FOREST LAKES FILING NO. 6

CONSTRUCTION PLANS

EPC STORMWATER REVIEW COMMENTS
IN ORANGE BOXES WITH BLACK TEXT

PCD Filing No.:
SF-20-027

FOREST LAKES FILING NO. 6			
GRADING AND EROSION CONTROL PLAN			
DESIGNED BY	MAL	SCALE	DATE 08/04/2020
DRAWN BY	MES	(H) 1" = 50'	SHEET 2 OF 30
CHECKED BY	(V) 1" = N/A	JOB NO.	1175.60

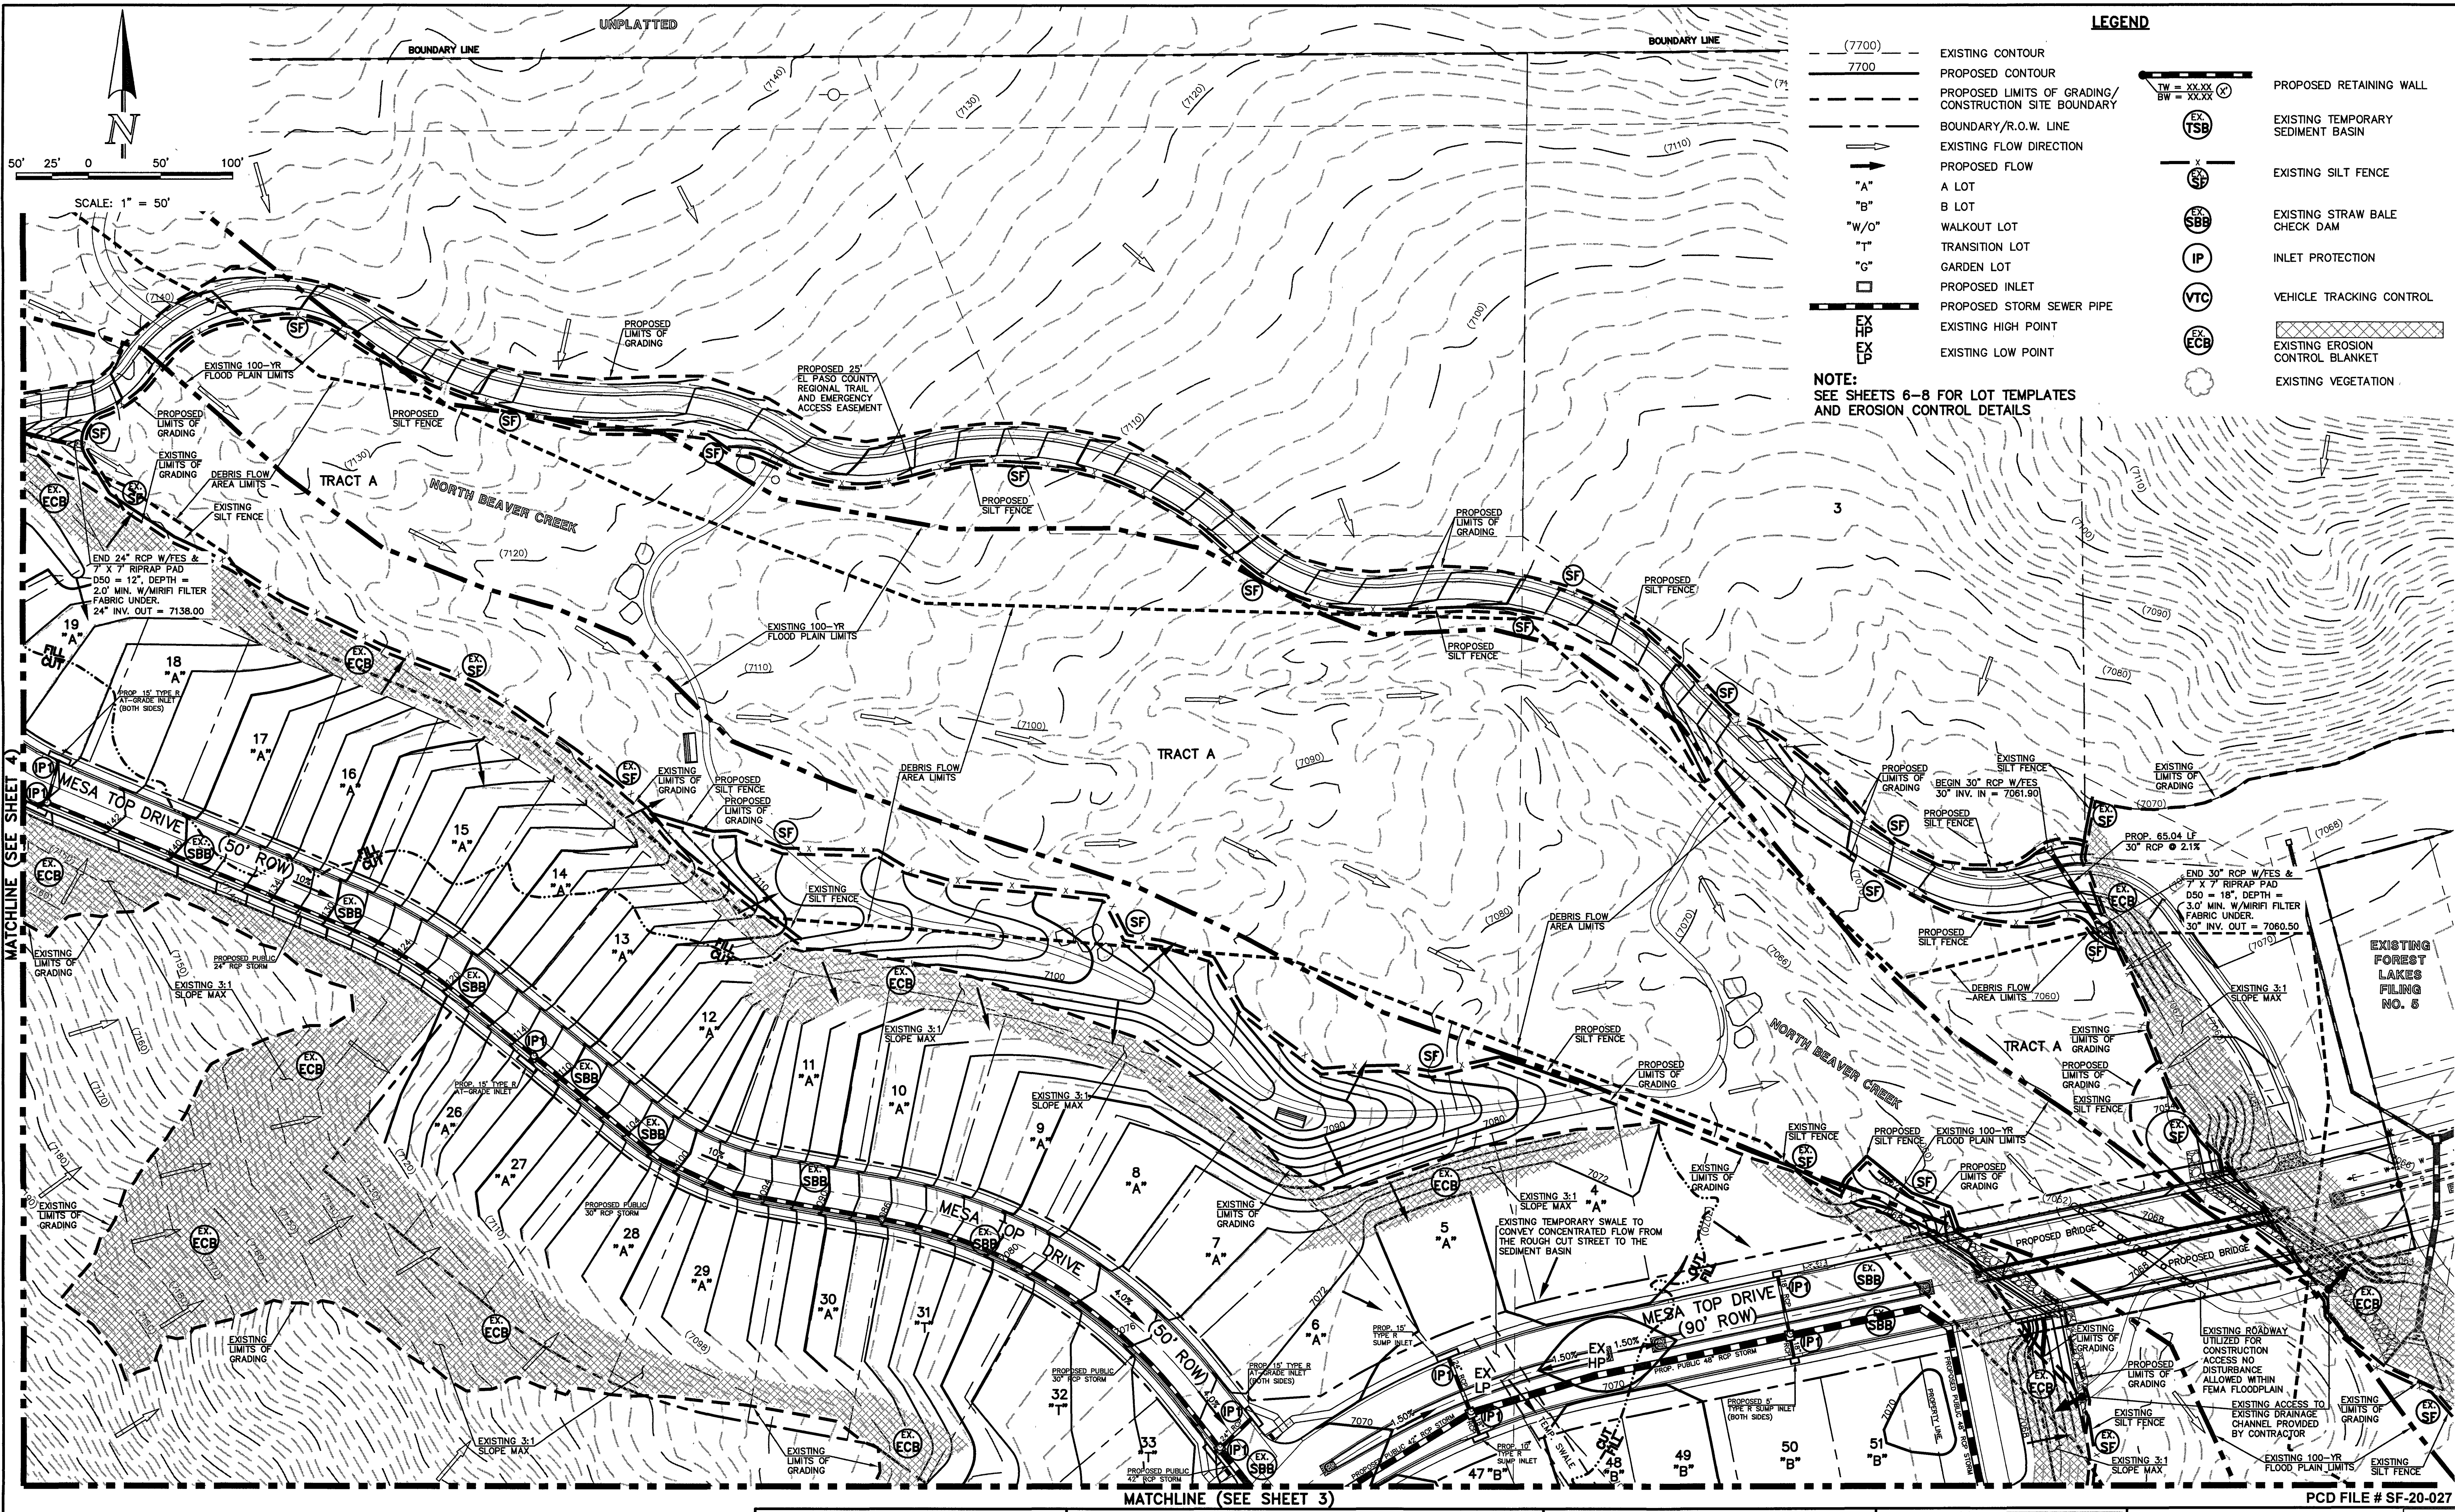
Checklist Item H - label Construction Site Boundary. If same as Limits of Grading, revise Legend text to say: "Proposed Limits of Grading / Construction Site Boundary"

SWMP Checklist Item 17d - Delineate areas of cut and fill

Show location of CWA, staging areas, and designated stockpiles. Or note that these locations are TBD.

Submit bridge plans for County review.

Revise to match in type shown in Legend (typ)

GRADING AND EROSION CONTROL PLAN

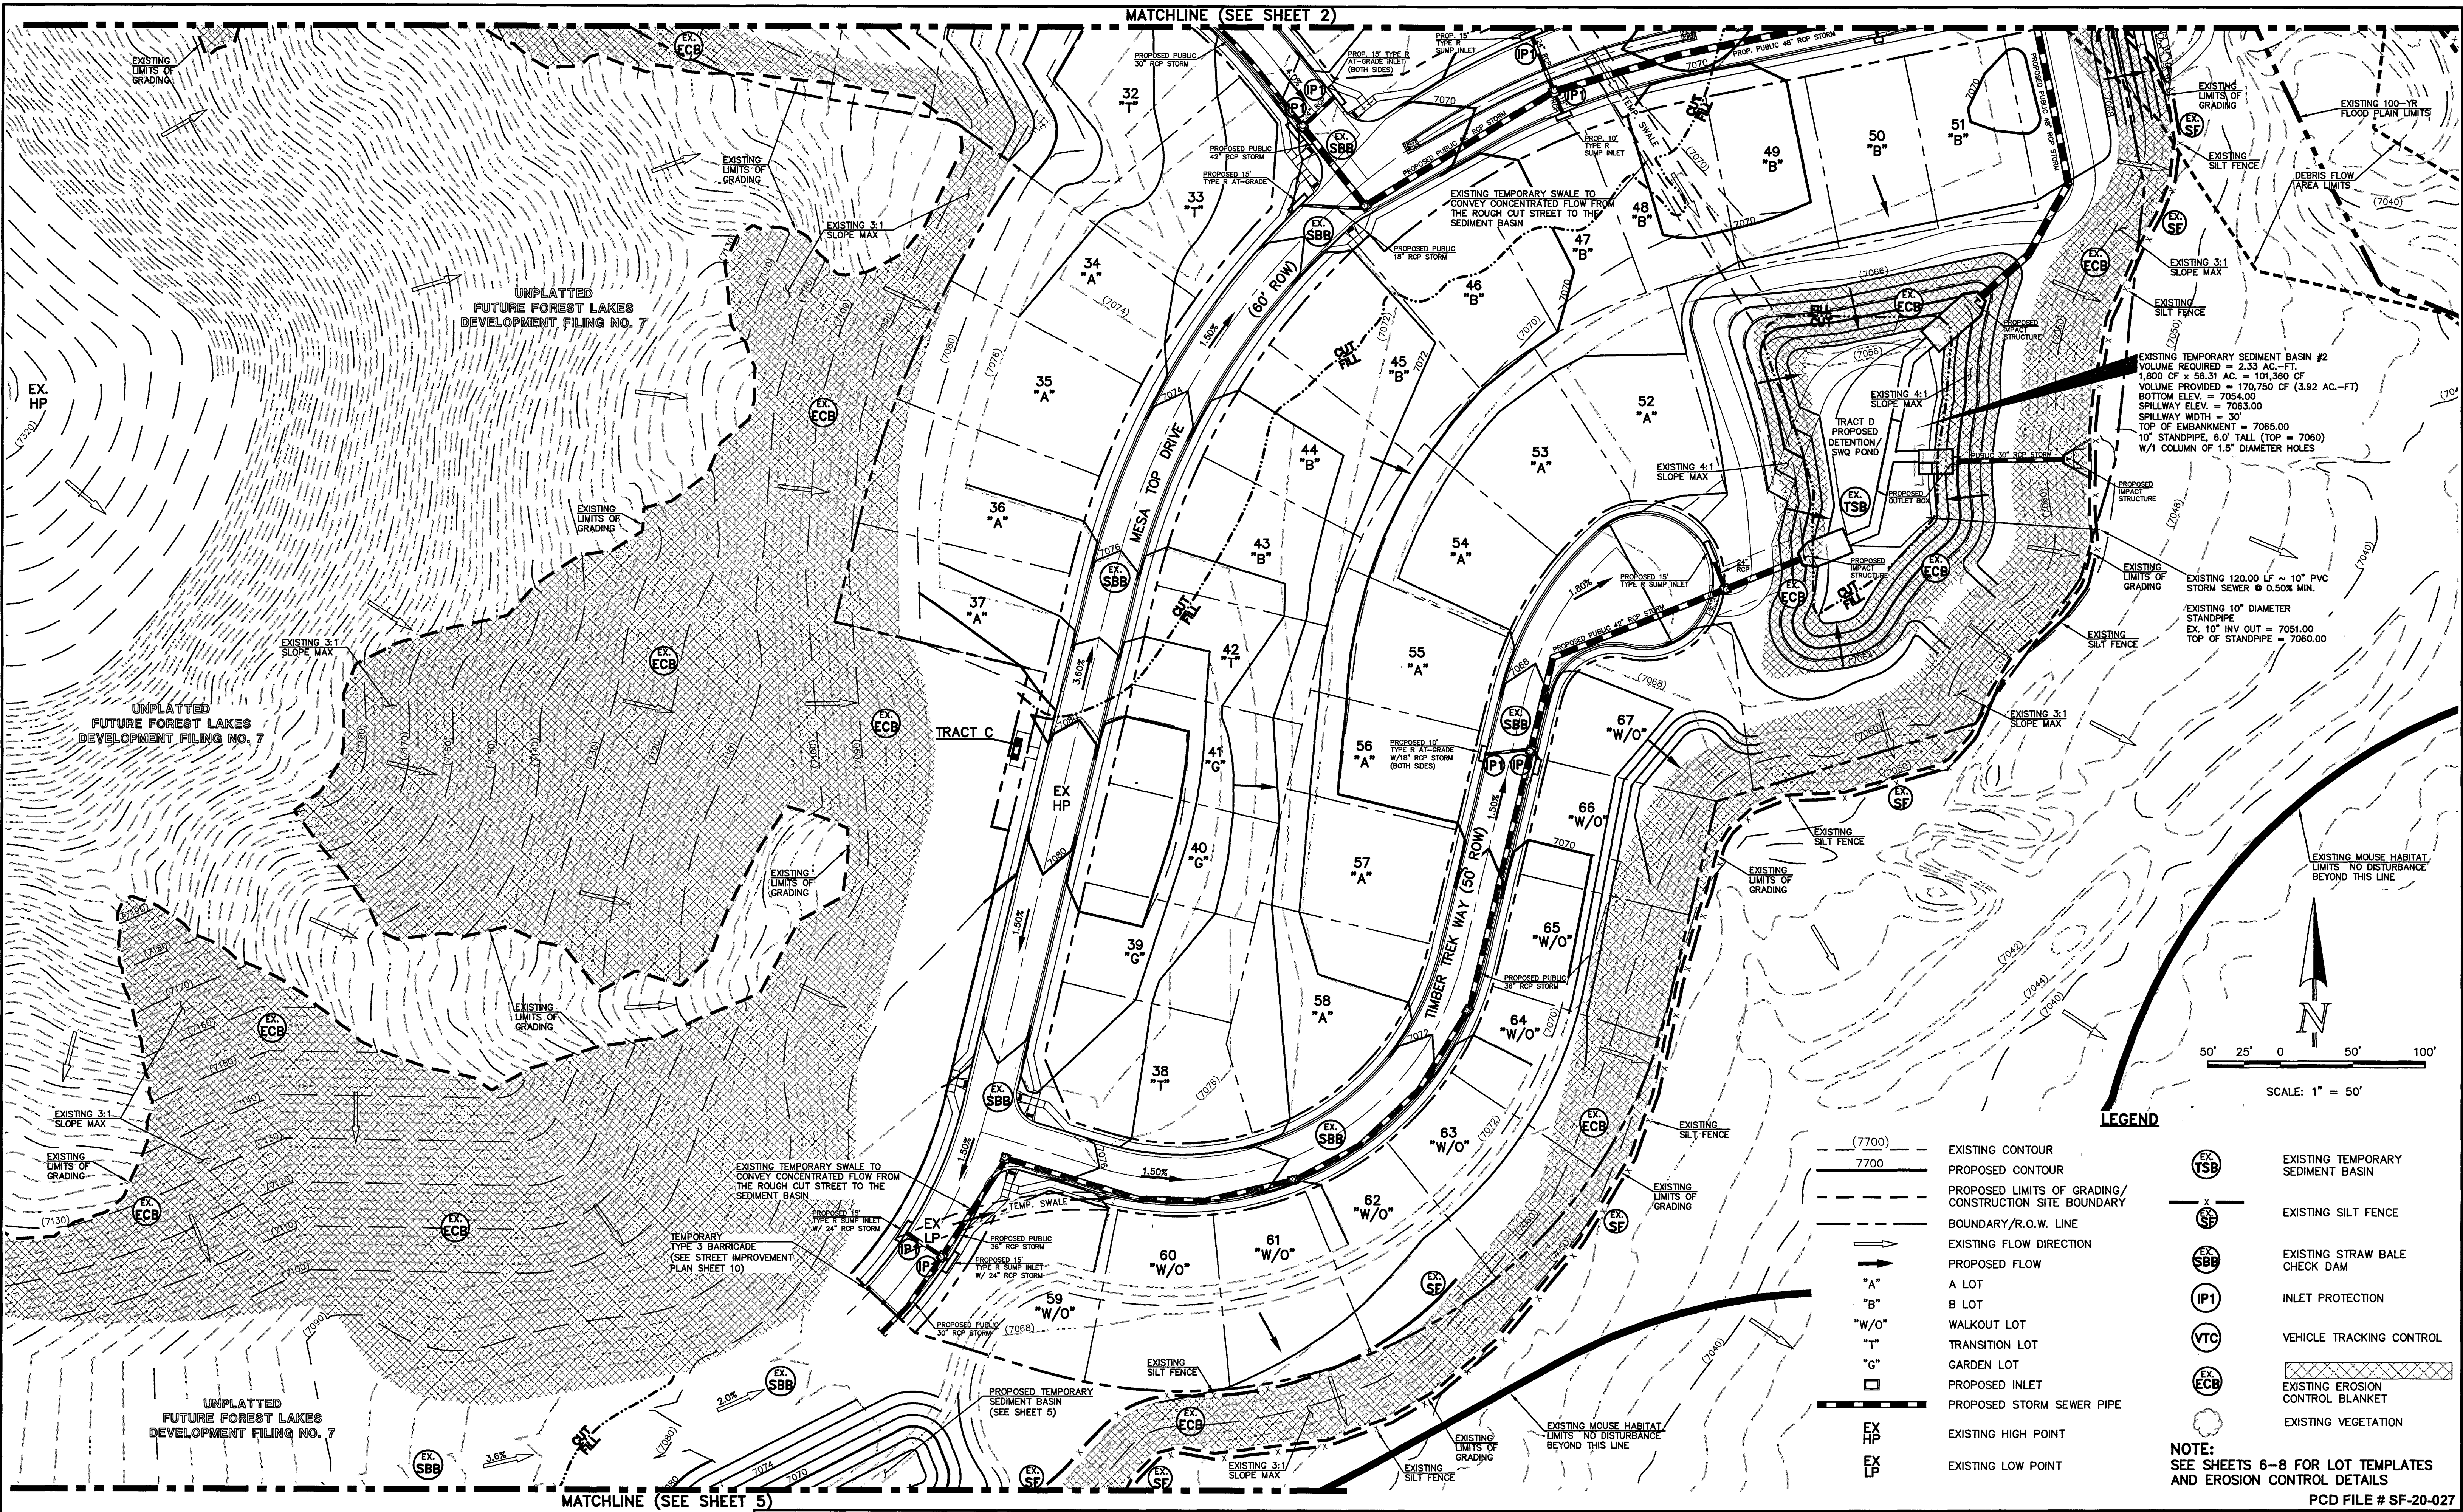
Install a barricade or if the area west of this Filing 6 improvement remains an active construction site then provide vehicle tracking control.
